From: Damian Sullivan
Sent: 29 August 2013 09:12
To: 'Simon Brodrick'
Subject: RE: R/152/13 8 West Mead, East Preston

Further to our conversation last Friday, just a reminder about confirming the deletion of the front boundary wall at the above address and amended plan of drawing number 15/13/06 dated May 2013 at your first convenience.

GARDEN WALL DETAILS

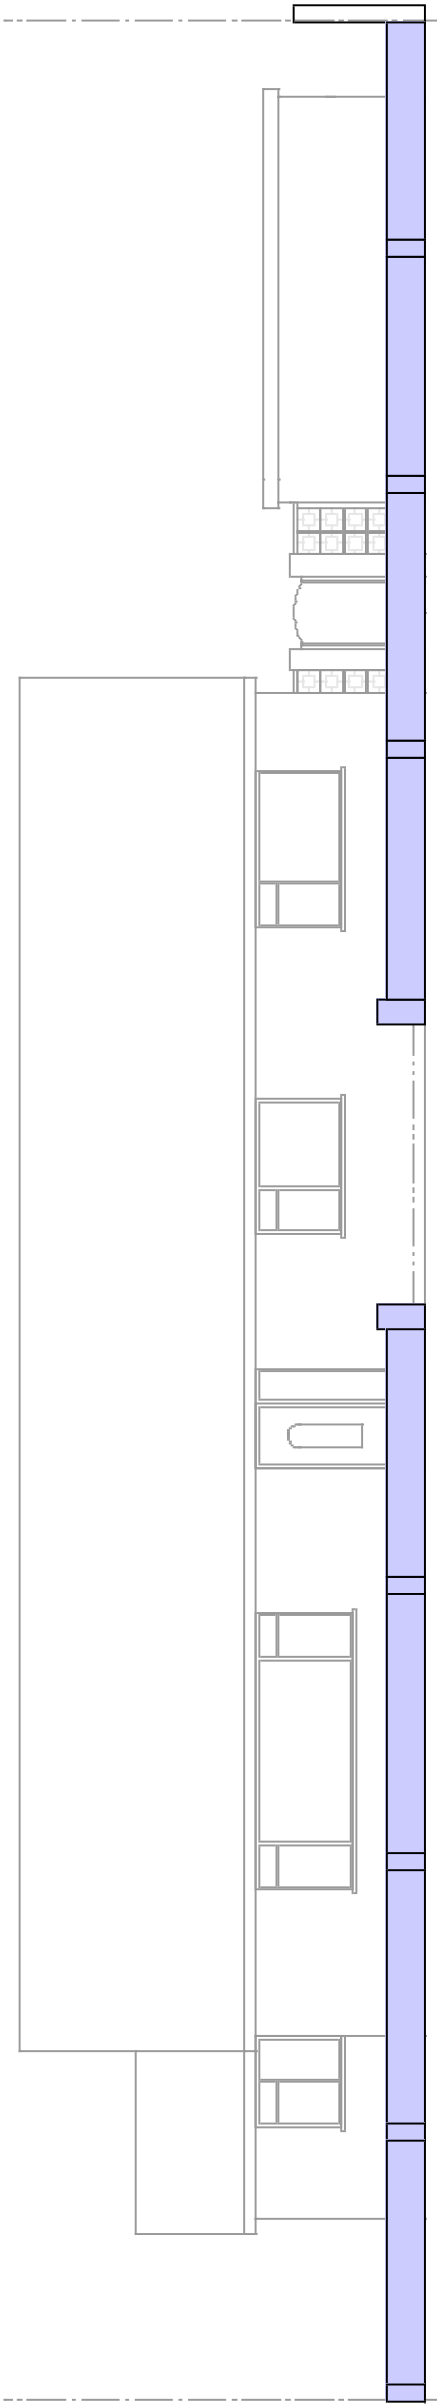
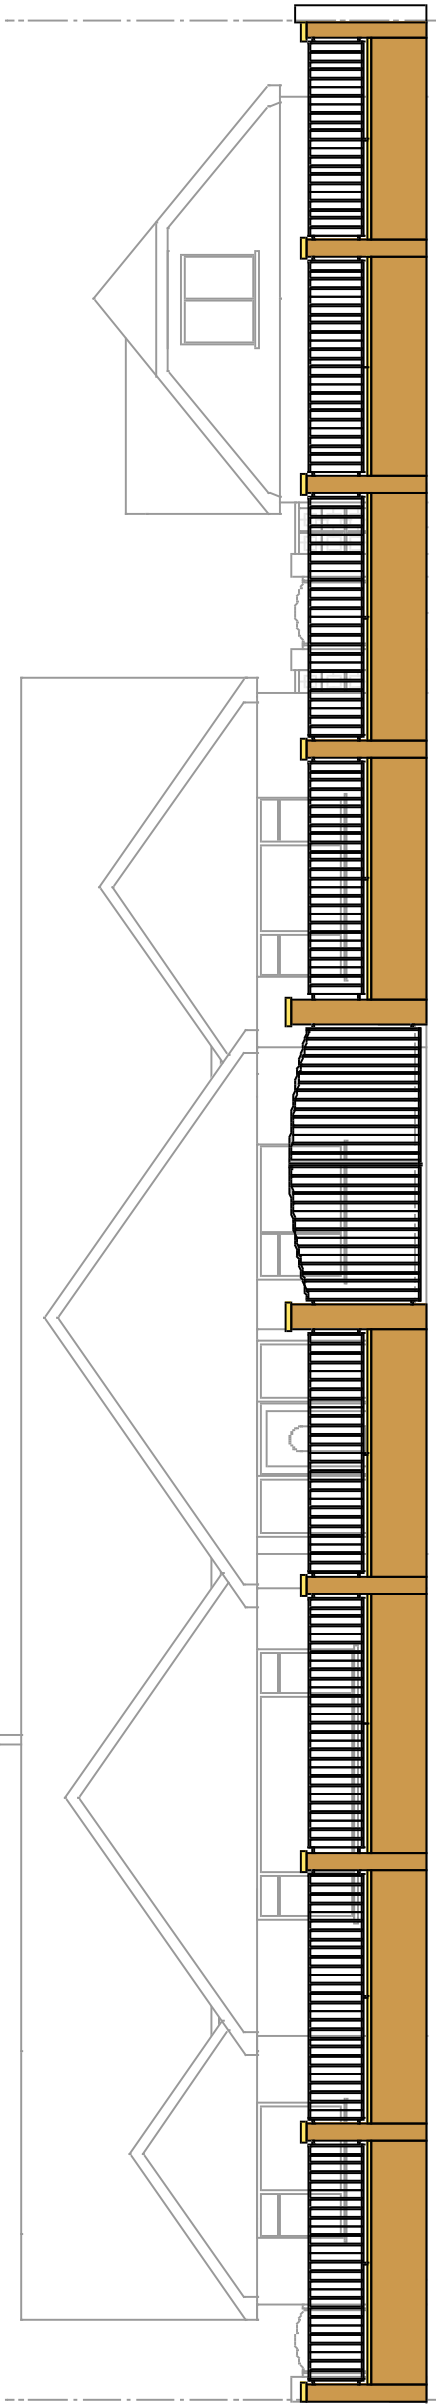
Thank you for your amended block plans – however I needed an elevation plan showing garden wall details (the one depicting the south elevation, existing and proposed) to be submitted. The proposed elevation would no longer show the wall in question. Please can you arrange for this to be sent to me at your earliest convenience.

Obviously my client would like to negotiate some kind of front boundary screening at some time but given that this may have a bearing on the existing proposal I agree to withdrawing this element of the plans which is shown on drawing no 15/13/06 - 03 and leave only the extensions to the dwelling and the garage.

Block Plan 1:500

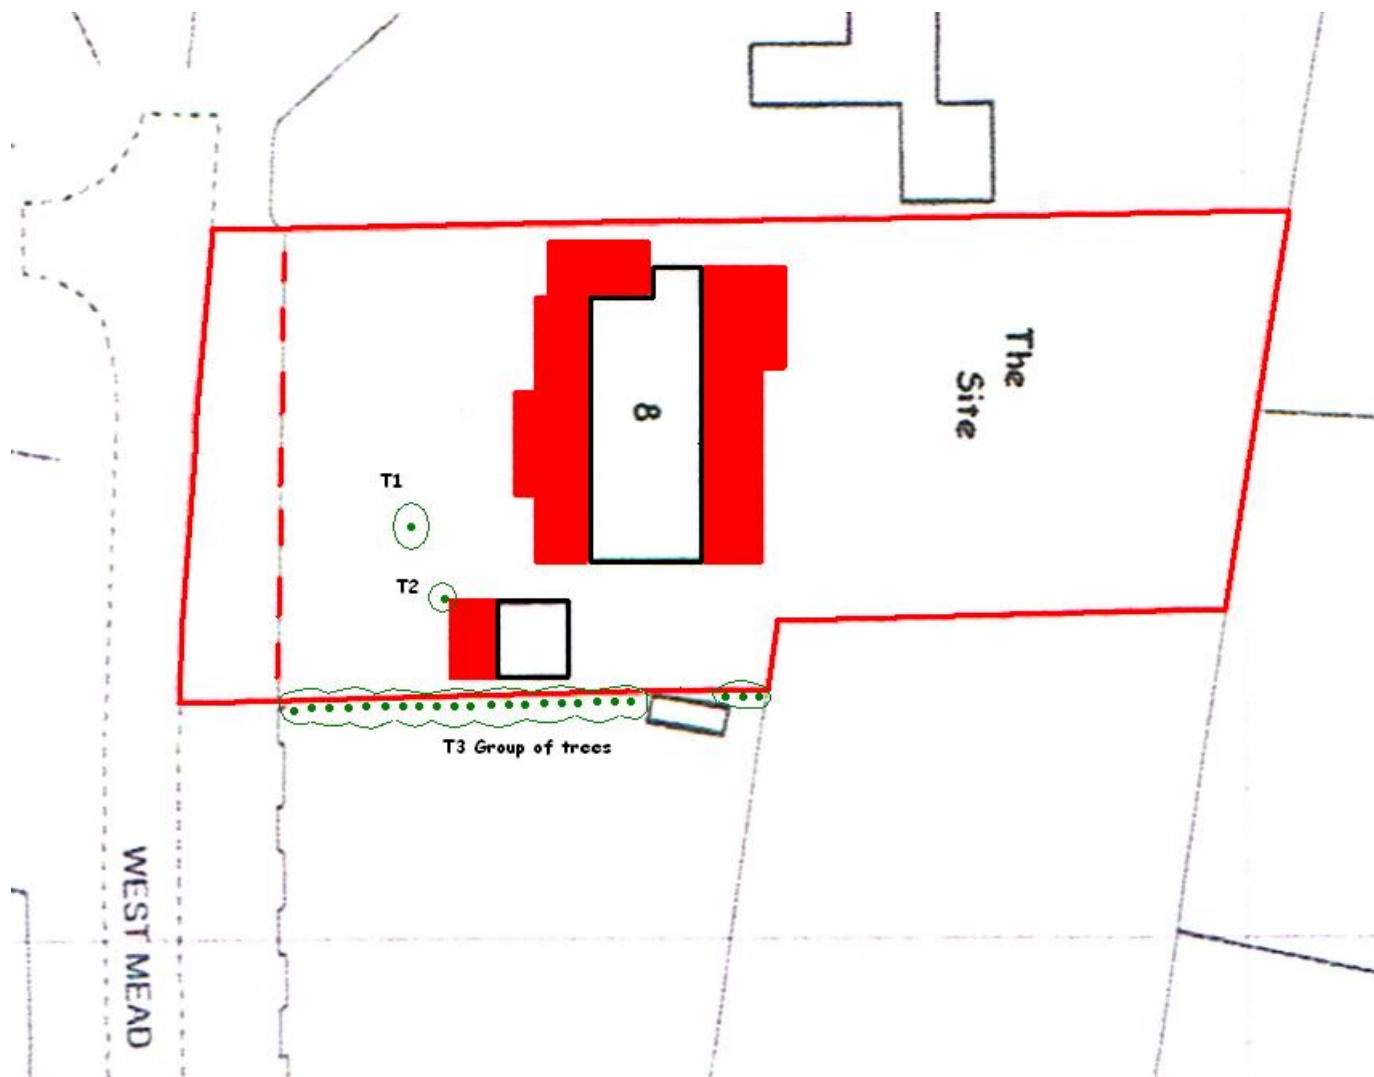
Please find attached revised drawing no 15/13/06-6A omitting the front garden wall as requested. I have also attached a revised Location drawing as this also shows the garden wall.

Thank you for your e-mail. However, I also need an amended plan to drawing no. 15/13/2006 not showing the proposed wall which can then supercede the existing plans. Please may I have this as a matter of urgency.
